Ref: 20018862

Cleve Hill Solar Park – Response to CHSP comments REP2-060 / REP3-058

I have now had the opportunity to review comments provided by CHSP (REP2-060/REP3-058) to my ALC report submitted 11th June 2019 and presented in the open floor hearing, dated 16th July 2019.

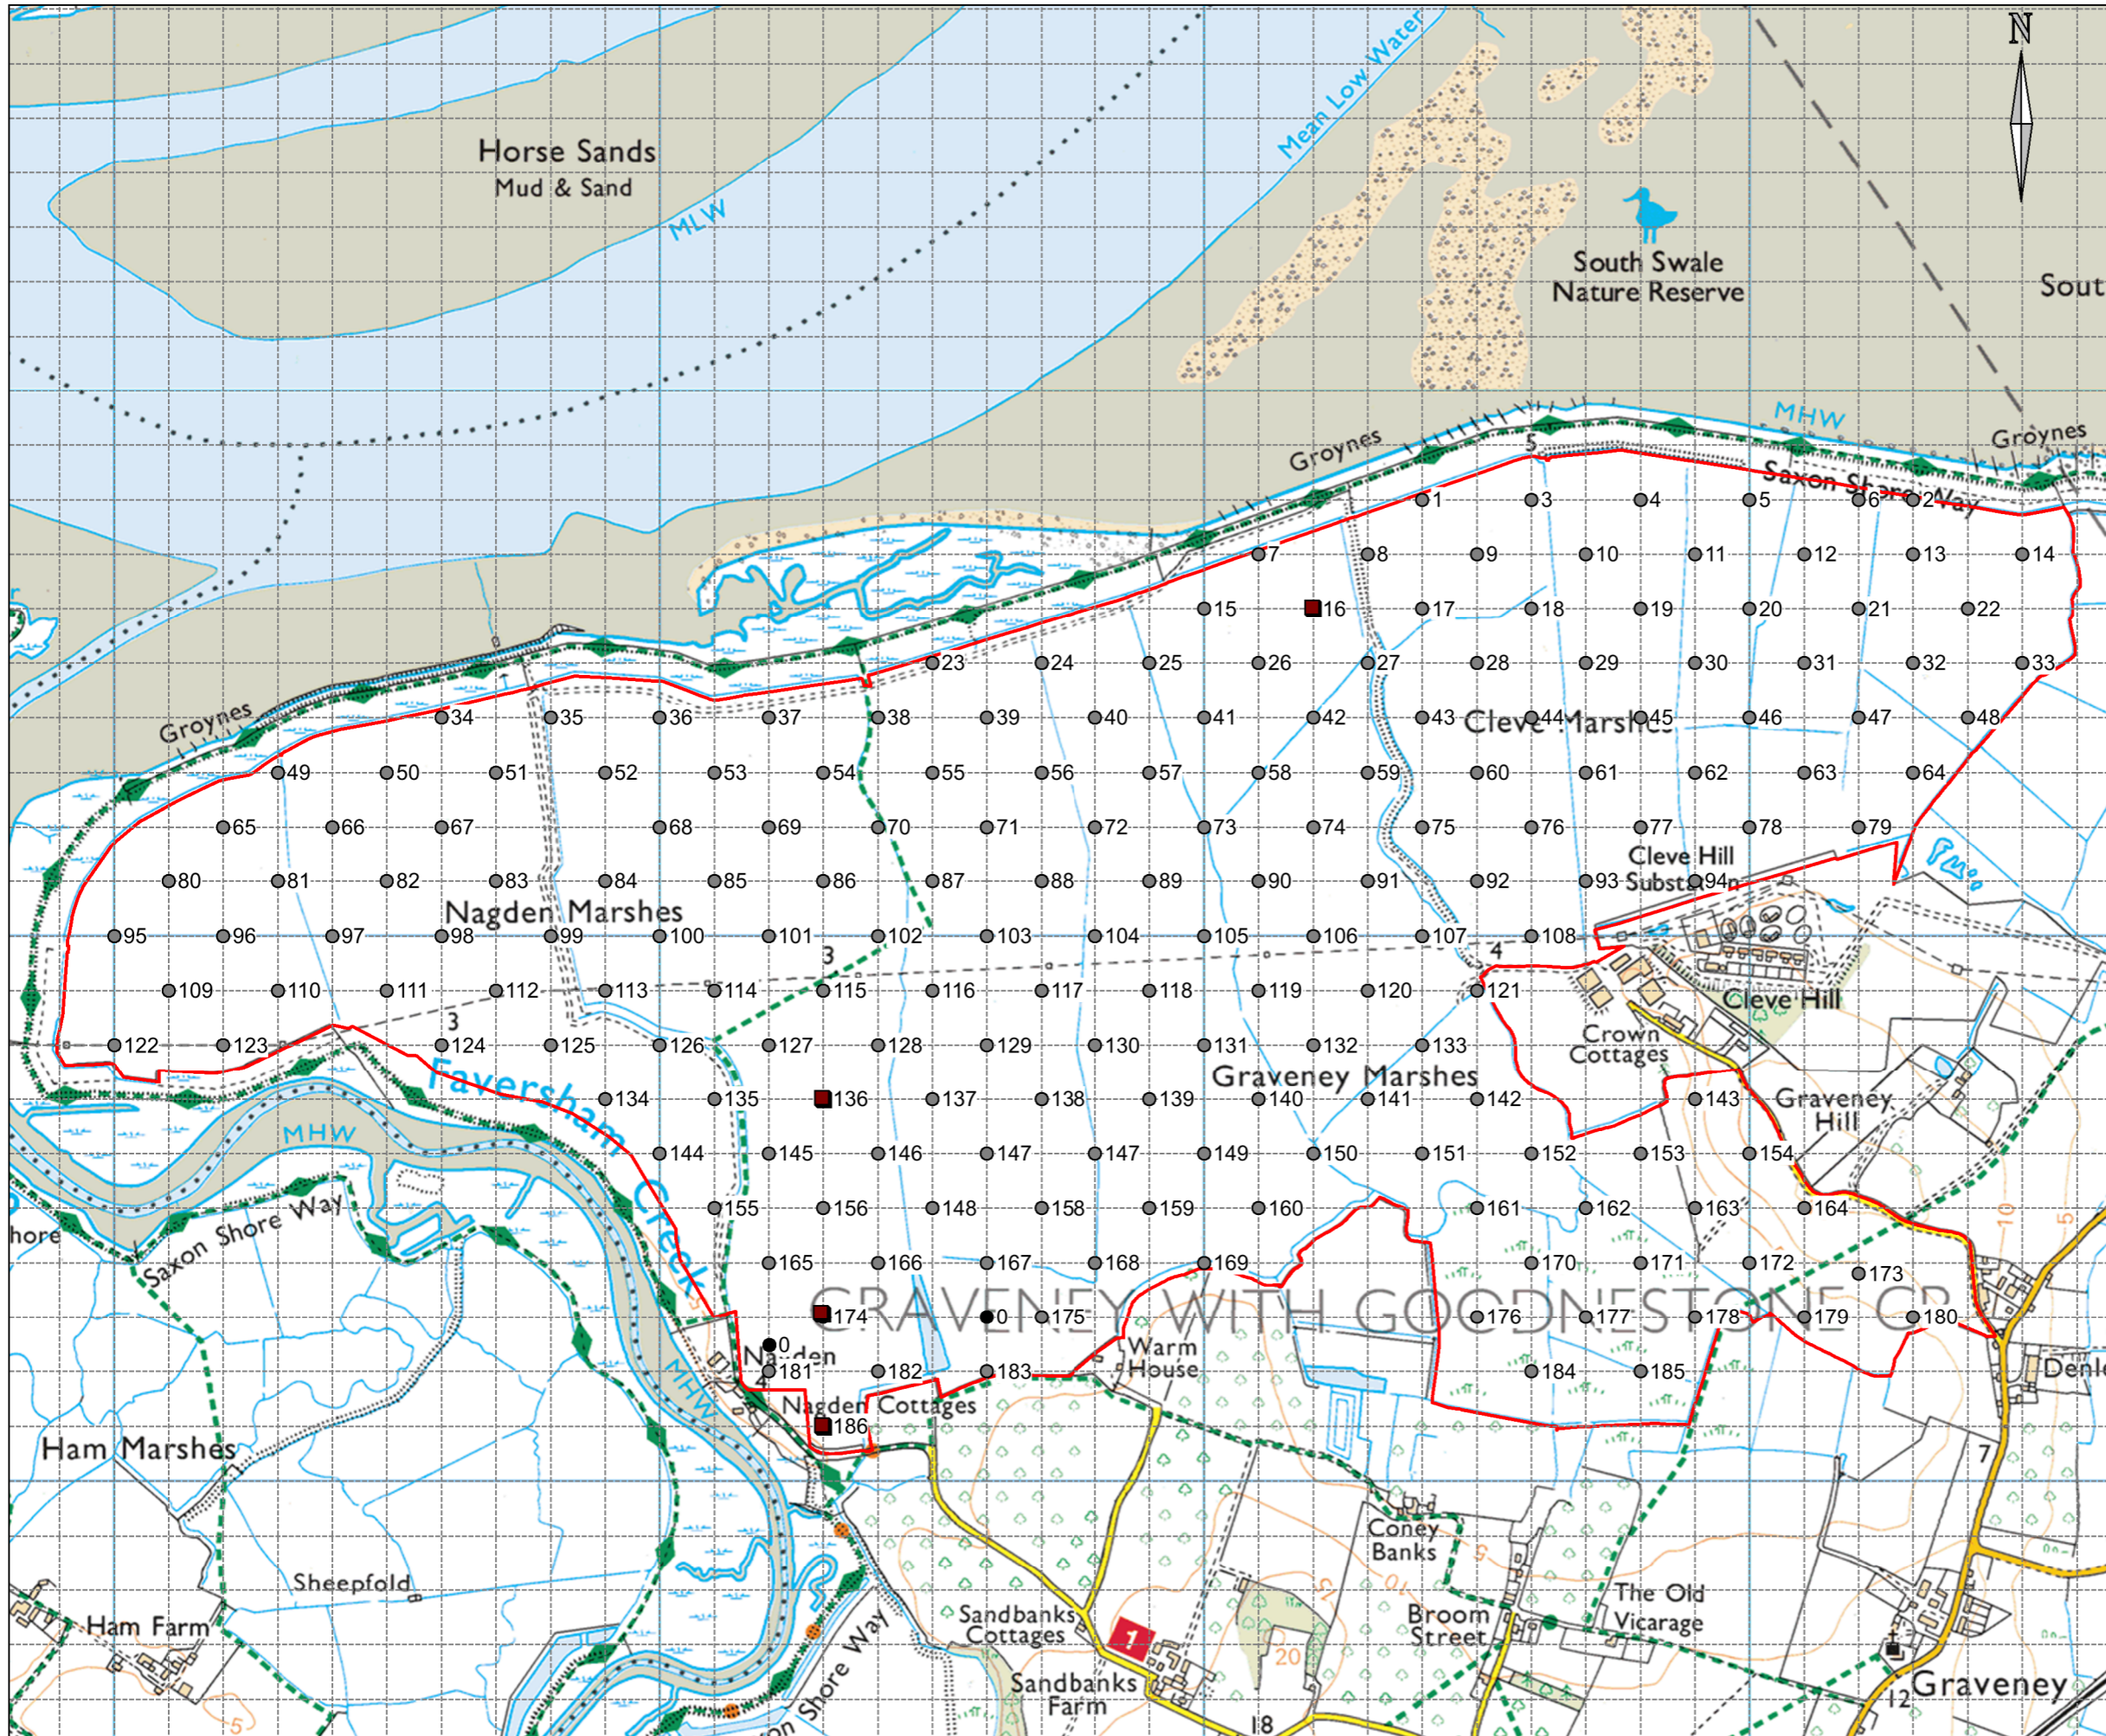
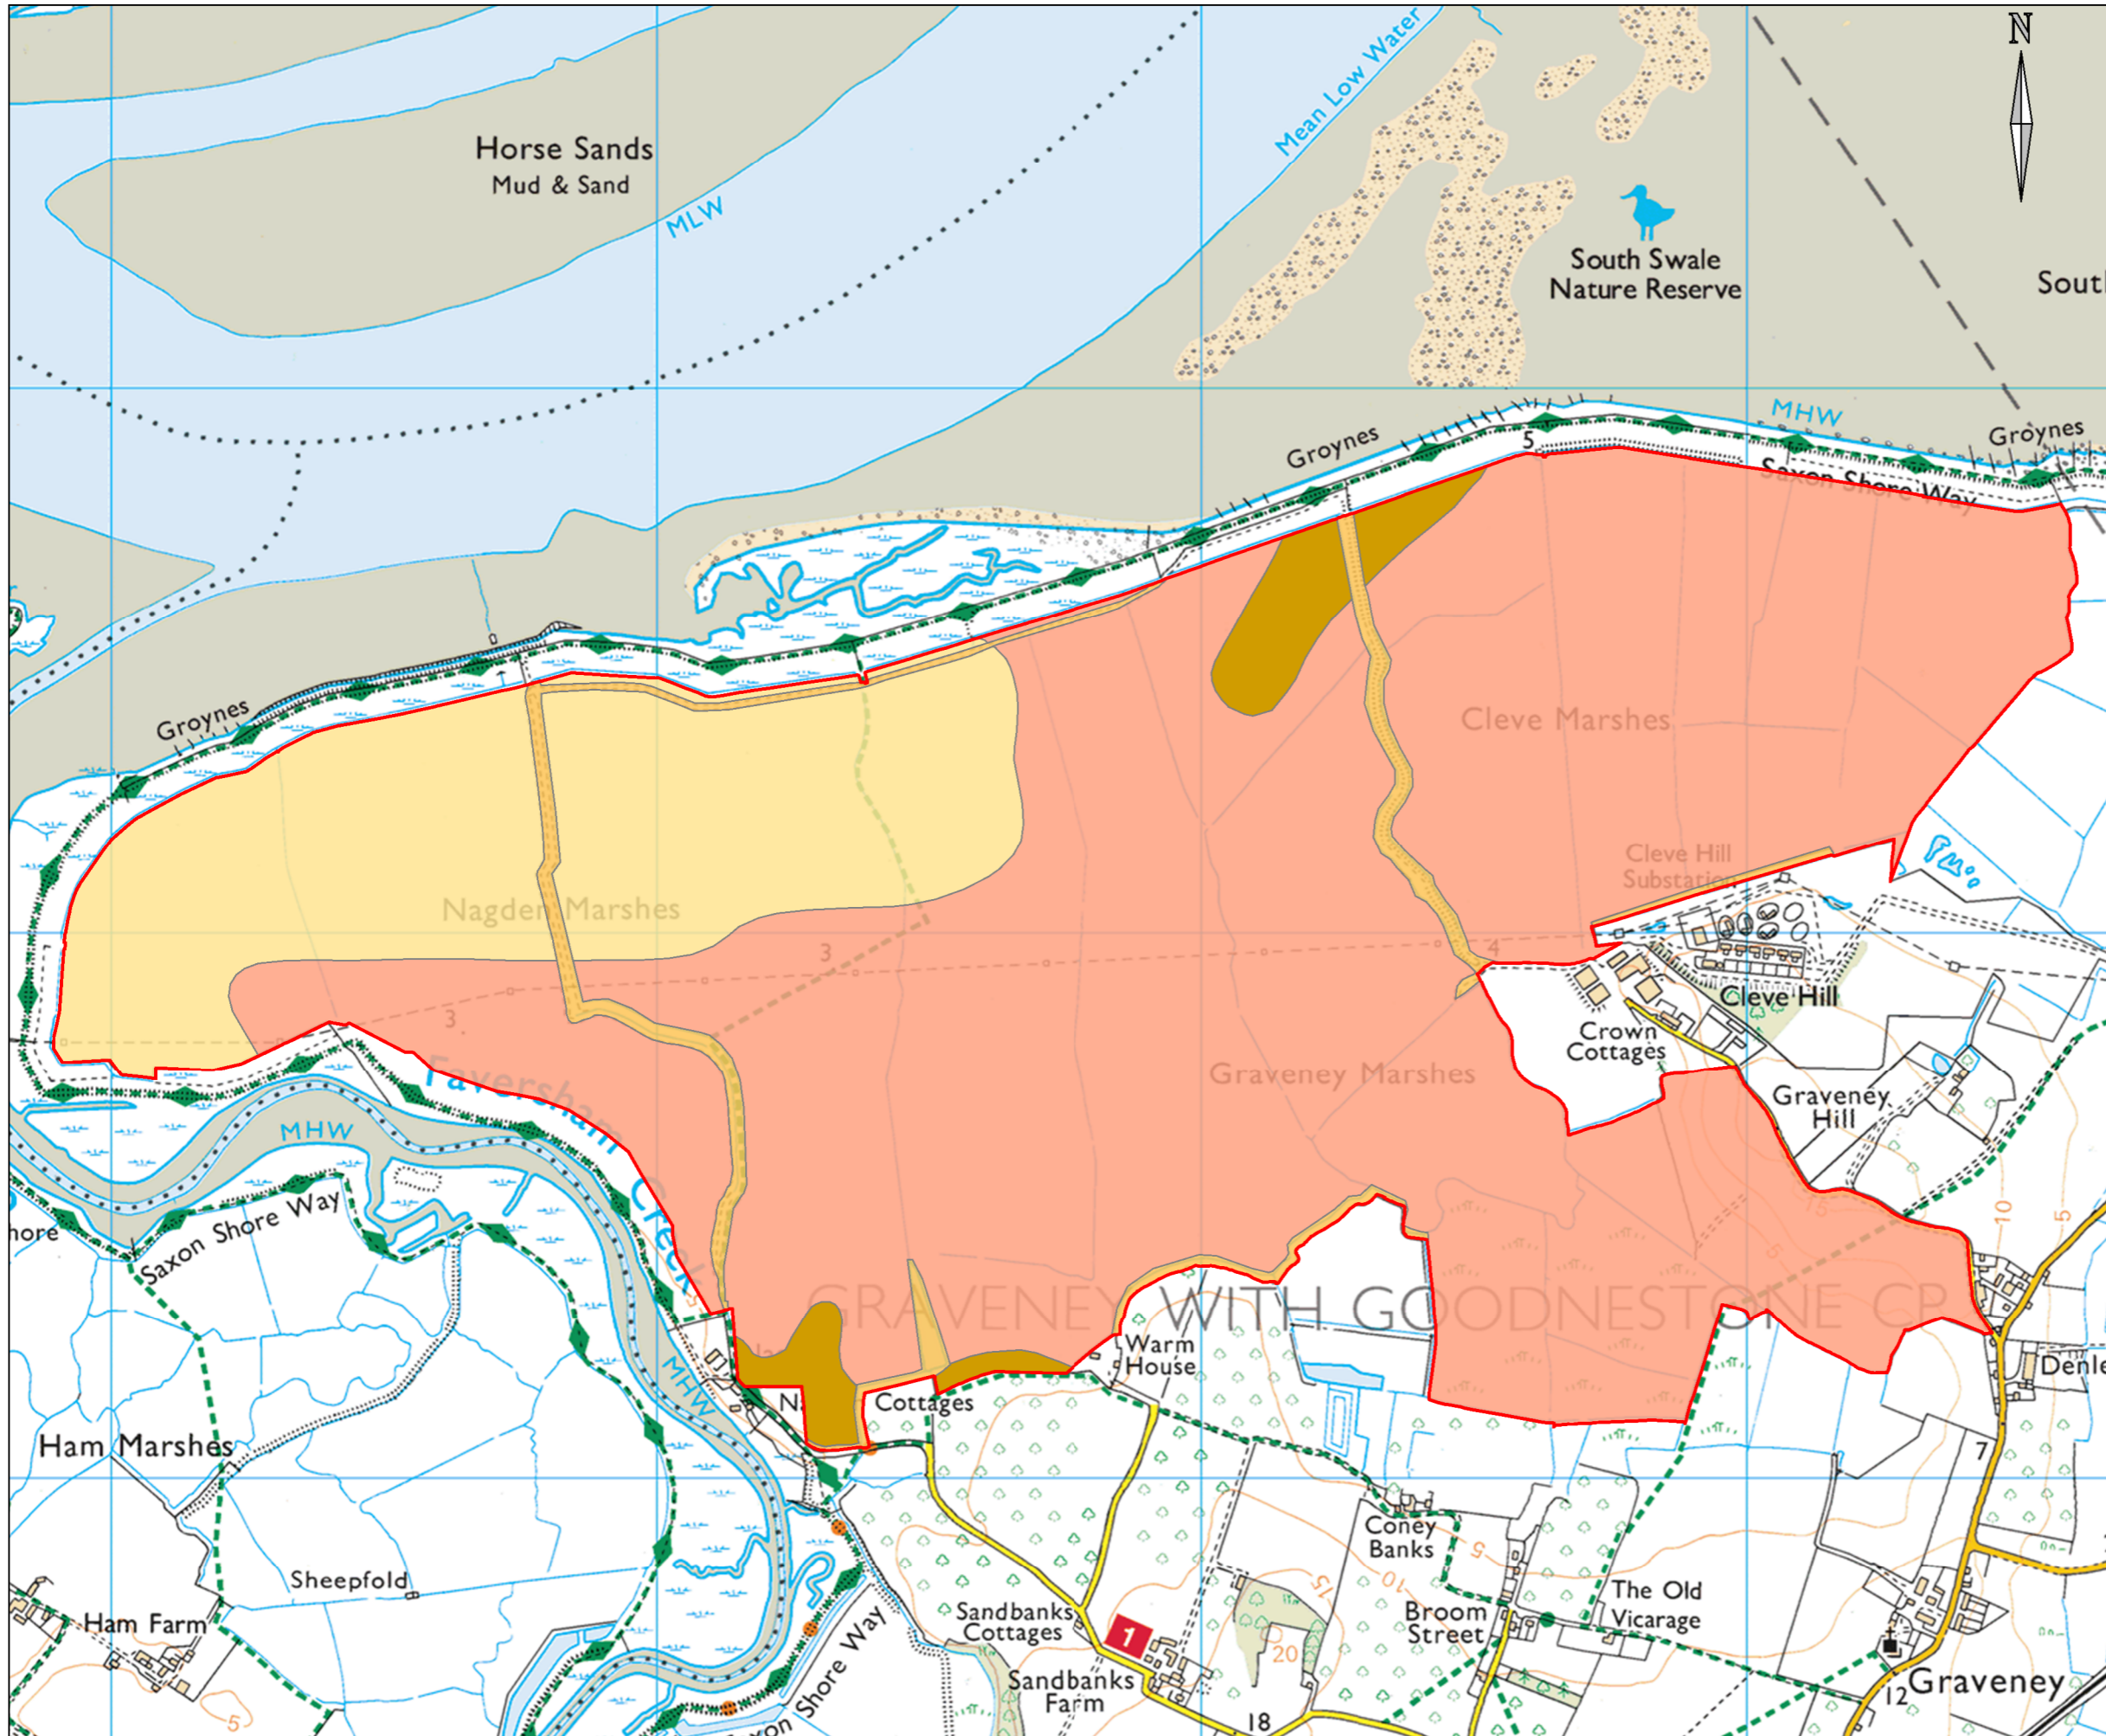
As pointed out in my previous report, three field observations namely 35, 37 and 54, should have been referred to Figure 8 (instead of Figure 7), in accordance MAFF 1988 guideline 'estimation of wetness class from depth to slowly permeable layer and duration of field capacity for soils with gleying present within 70 cm depth but not within 40 cm and a slowly permeable layer starting within 80 cm depth' end of quote. Thus based on the field capacity, these three field observations should have been clearly interpreted as Wetness Class II.

Thus, for the correct interpretation of the MAFF 1988 guideline, the field observation presented in the CHSP ALC report Appendix table named ‘Land at Cleve Hill Farm: ALC and soil resources survey – details of observation at each sampling point’, namely 1, 5, 6, 7, 8, 8a, 9, 11, 13, 15, 16, 18, 21, 23, 24a, 26, 29, 32, 33, 34, 35, 36, 37, 38, 39, 41, 48, 49, 50, 51, 52, 53, 54, 55, 56, 64, 65, 66, 68, 70, 71, 80, 81, 82, 83, 84, 85, 86, 87, 95, 96, 97, 98, 99, 100, 101, 102, 104, 115, 117, 122 and 160, should have been interpreted to be subgrade 3a, due to the presence of CaCO₃.

I have now reviewed these additional observation points and identified 10 locations, which have calcareous top soils, including 124, 127, 134, 135, 138, 139, 144, 147, 149, 152 and 155.

Having now obtained the missing field observation data from CSHP, it is apparent that only one single field observation details a gradient of 9 (observation 143). This single gradient exceedance is only equivalent to about 0.5% of the total land assessed. Thus about 99.5% of the entire land has no gradient limitation and is in fact very flat and hopefully this was noted by the Planning Inspectorate during public viewing of the area. No actual field observation data are presented within the CSHP ALC report detailing gradients of 7 and 11 degrees.

- Therefore, the statement presented in the CSHP ALC report, paragraph 3.9, page 6, quote 'gradient is therefore an equally limiting factor on this land' is inaccurate, as 99.5% of the entire survey area or equivalent to 372 ha is entirely flat.
